## Planning Comments

### Project# 1005191

14DRB-70199 - PRELIMINARY PLAT

14DRB-70200- SITE DEVELOPMENT PLAN FOR SUBDIVISION

Sheet Title MASTER GRADING AND DRAINAGE PLAN	Sheet Number SP3
Date MAY 2, 2014	
Project No.

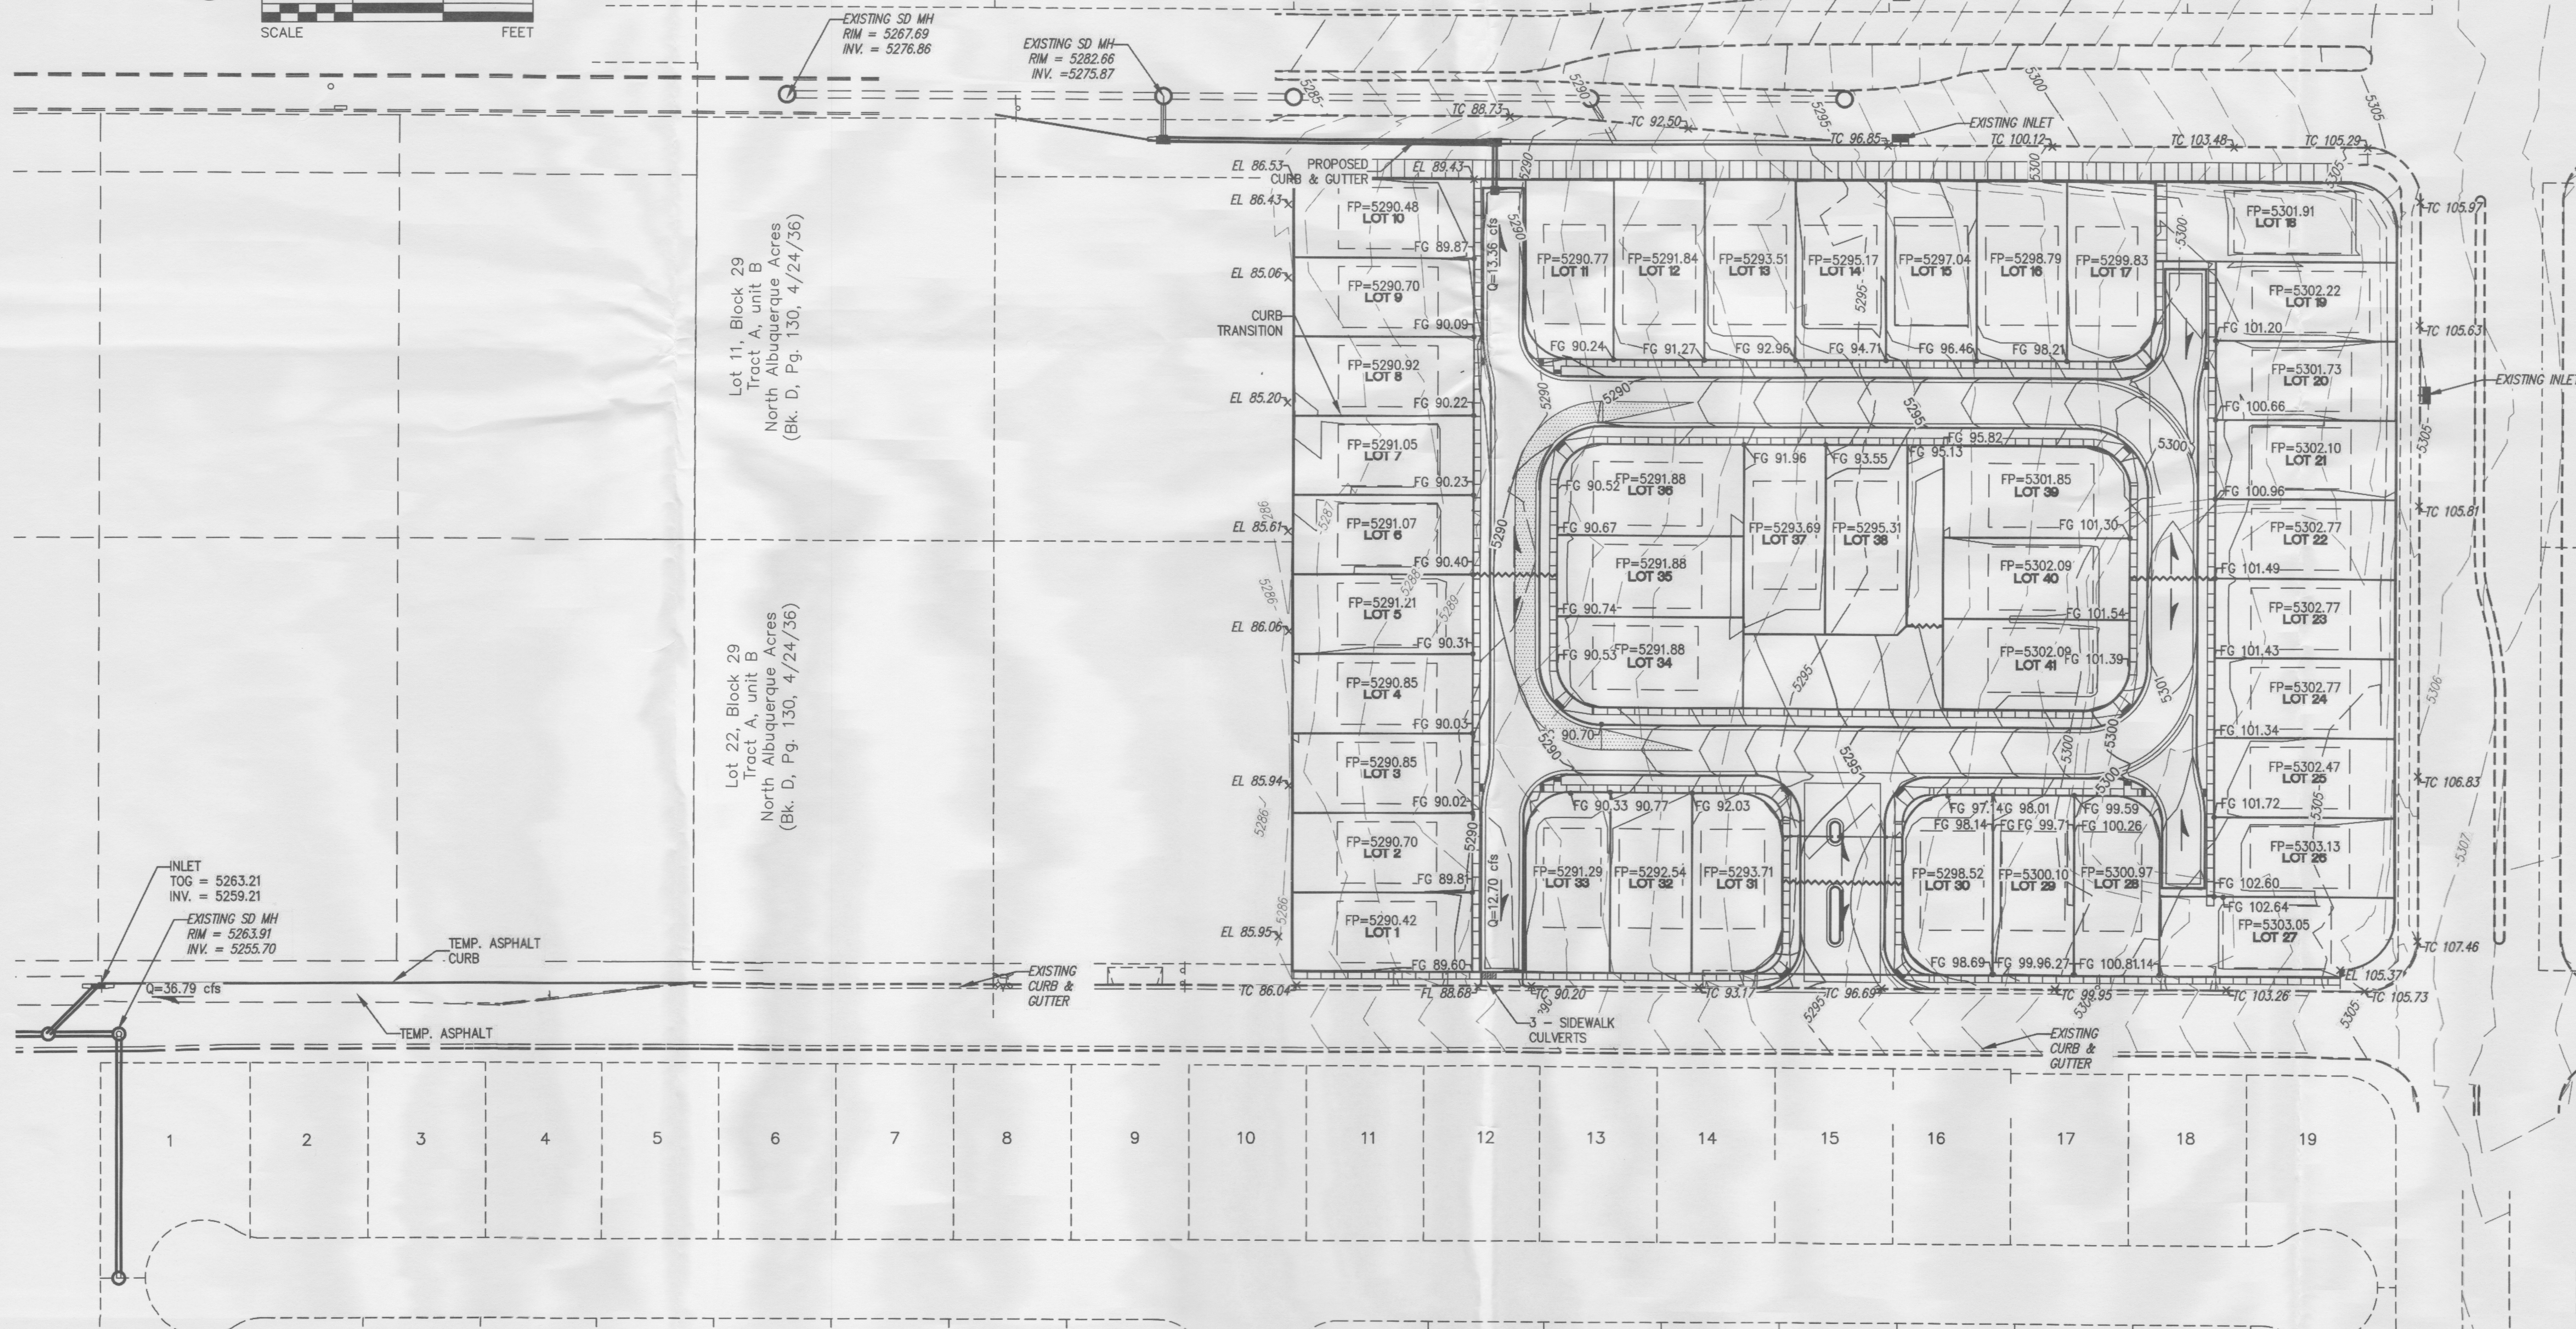
Grading and Drainage Plan shows a retaining wall along the east side of the "park" but landscaping is shown too close to wall to reach mature spread.

Sheet Title	Sheet Number
SITE DEVELOPMENT PLAN	SP1
Date	
JUNE 6, 2014	
Project No.

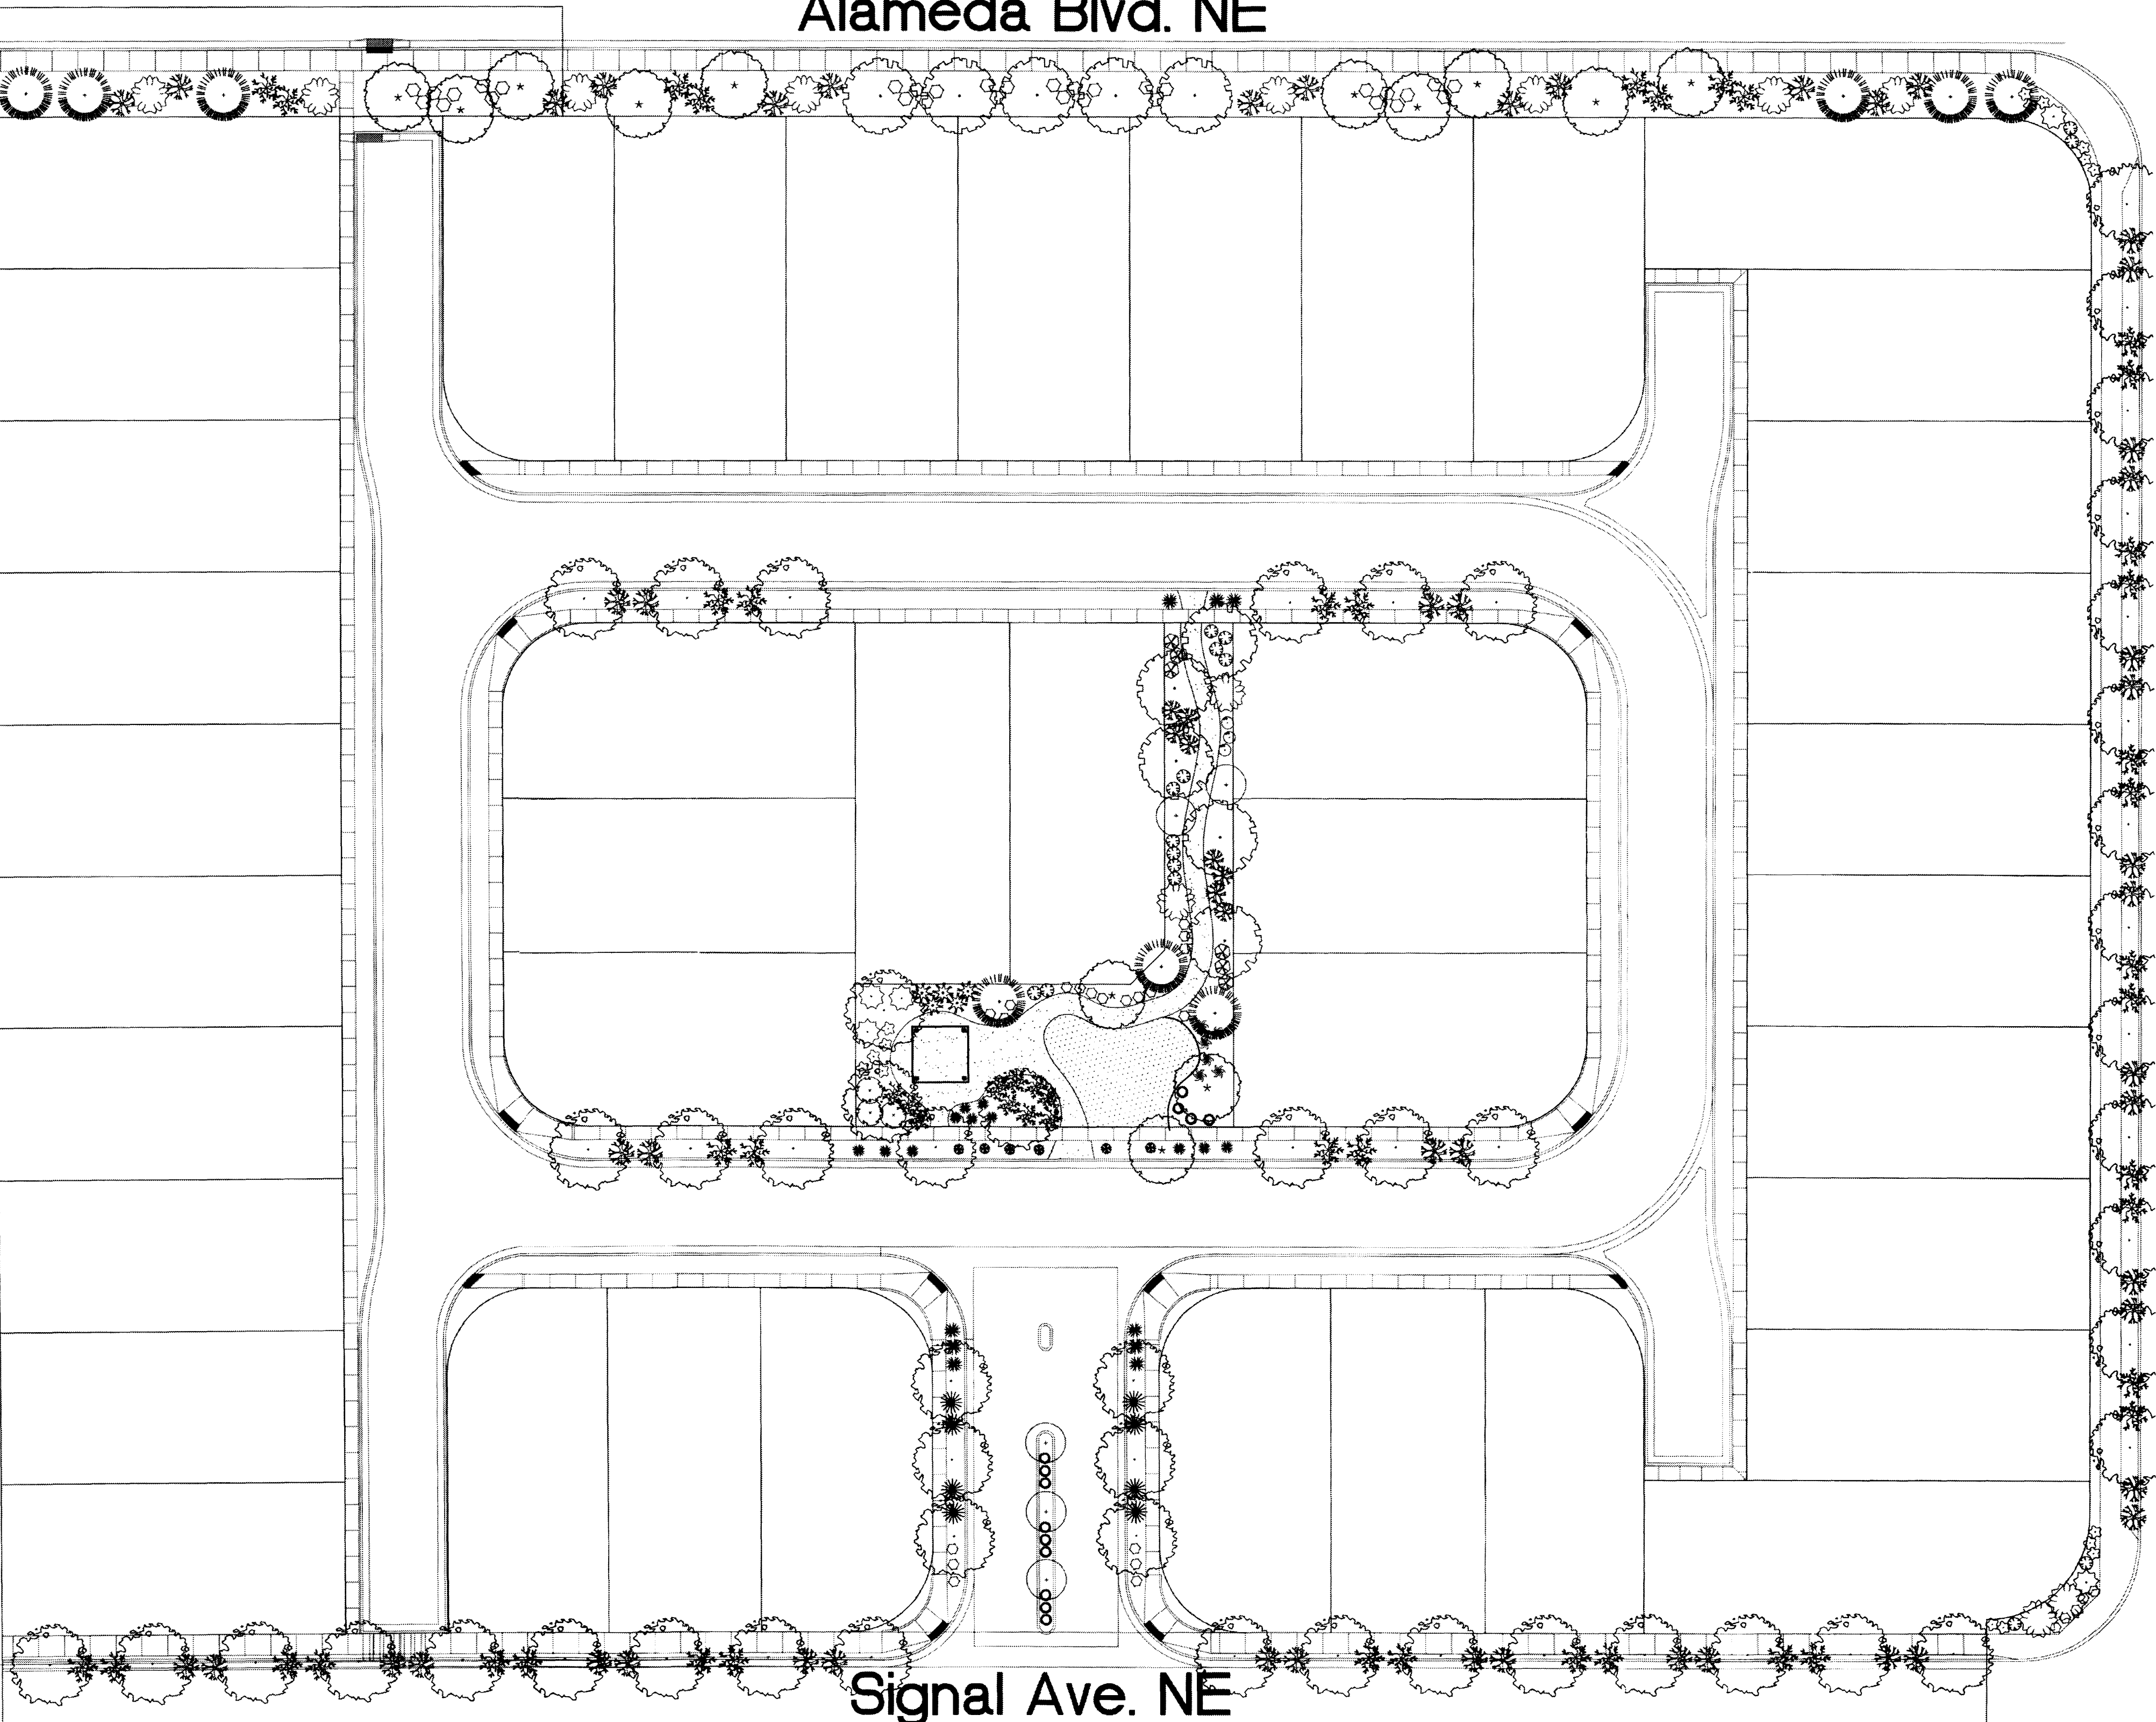
Lot numbers and street name should be shown on the site plan drawing. There is a typo on the plan drawing for Tract A which needs to be corrected to match the Keyed Notes. The Subdivision Data table needs to identify Tract A and private street area. Driveway locations need to be shown on the plan drawing with adequate separation for mid-lot curb ramp locations (Lots 3, 8, 20 & 25).

Public sidewalks (Alameda, Signal) need to be located at property line per DPM standards. A Keyed Note 6 is needed for the proposed pedestrian connection to public right of way in the southwest corner of the site, or the sidewalk should be truncated at Lot 1 driveway and shown on the plan drawing. The sidewalk should also be truncated at Lot 27 driveway and shown on the plan drawing. An additional pedestrian connection to public right of way is needed in the northeast corner of the site.

Open Space requirements need to be addressed on the site plan. The 'Typical Lot' on the site plan scales at 50 ft wide but the plan drawing and plat show 44 ft wide lots; the proposed setbacks with 44 ft wide lots indicate over 500 sq ft deficiency per lot, and this includes proposed Tract A.

To avoid confusion, please use consistent term for the "central landscaped area". The Sheet SP1 note 1.1 refers to "centrally located landscaped area with shade structure and community mailboxes", Note 1.3 calls it a "centrally located park", Note 1.5 calls it a "centrally located landscaped park" and Landscape Plan Sheet L2 is titled "Pocket Park". Also, it has keyed note 2 which should be 12.

Where are gang type mailboxes discussed in Note 1.1 and shown as key note 11?

Where is keynote 10?

SHEET #
L1 of L3

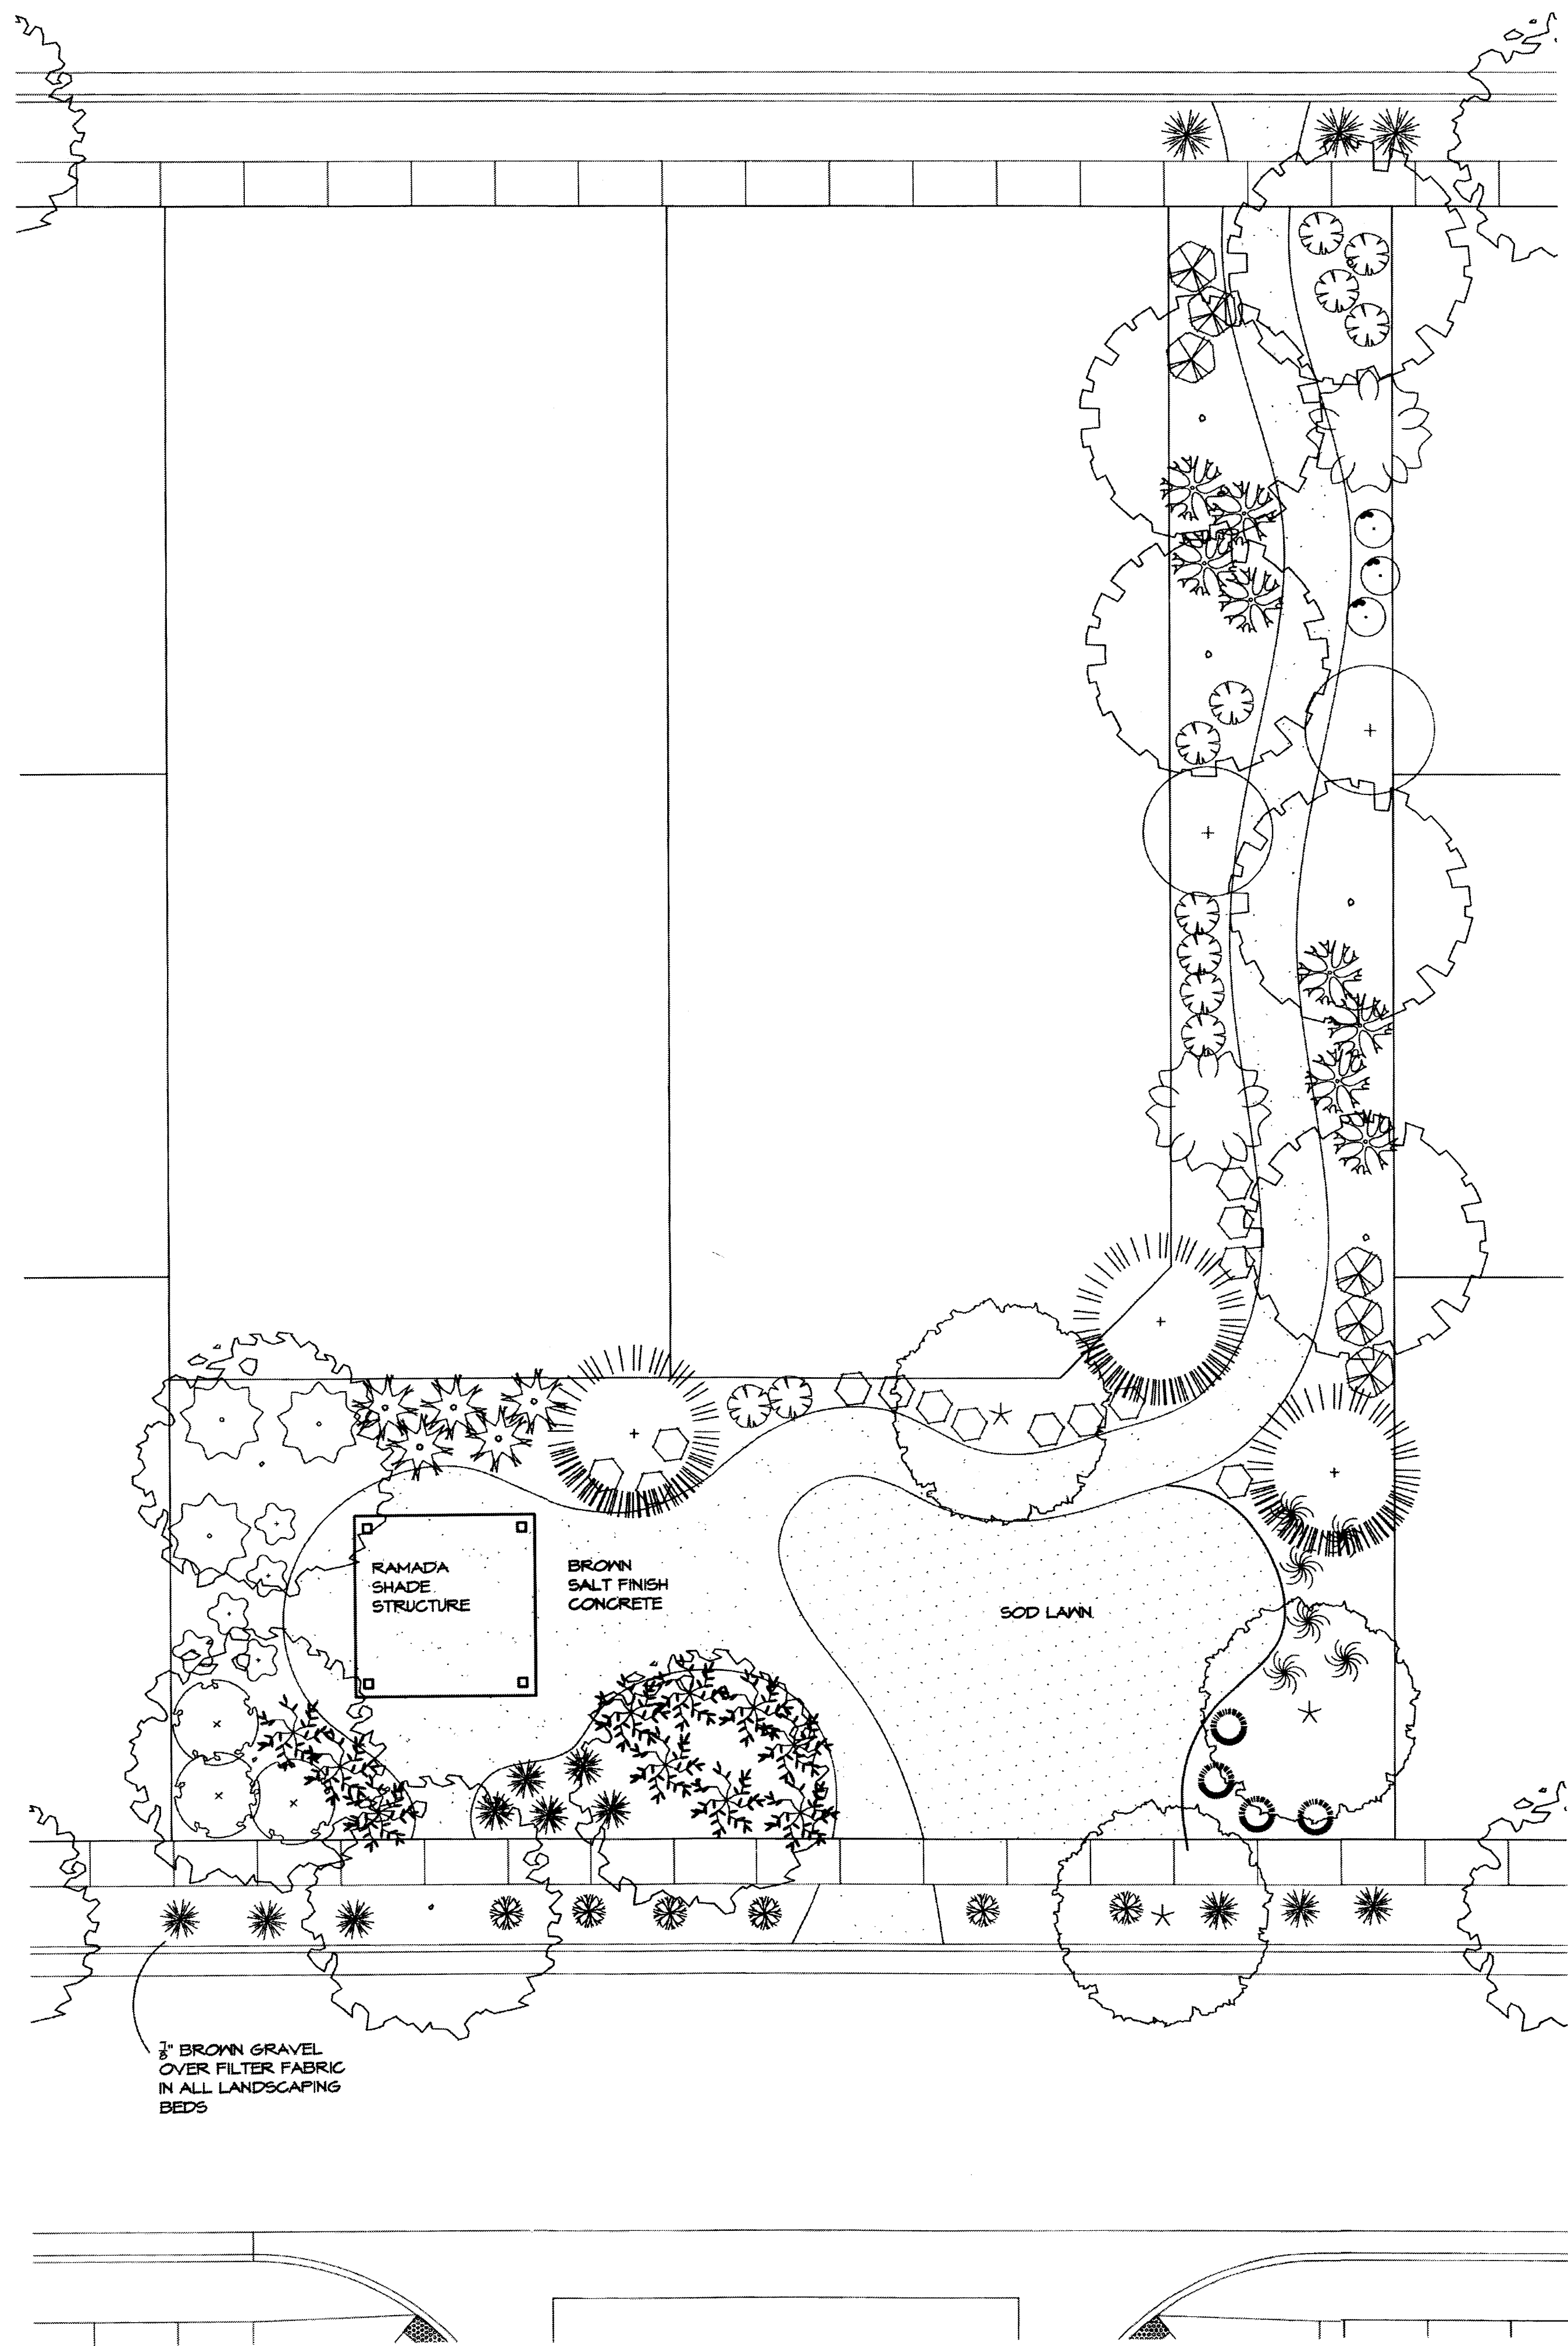
Please confirm the spread of the trees are shown to scale on the Landscape Plan Sheet L1 match the spread indicated on the Plant Legend especially the three Austrian Pines shown near the intersection of Alameda and Louisiana. Please confirm that the Pines are outside the clear zone at maturity.
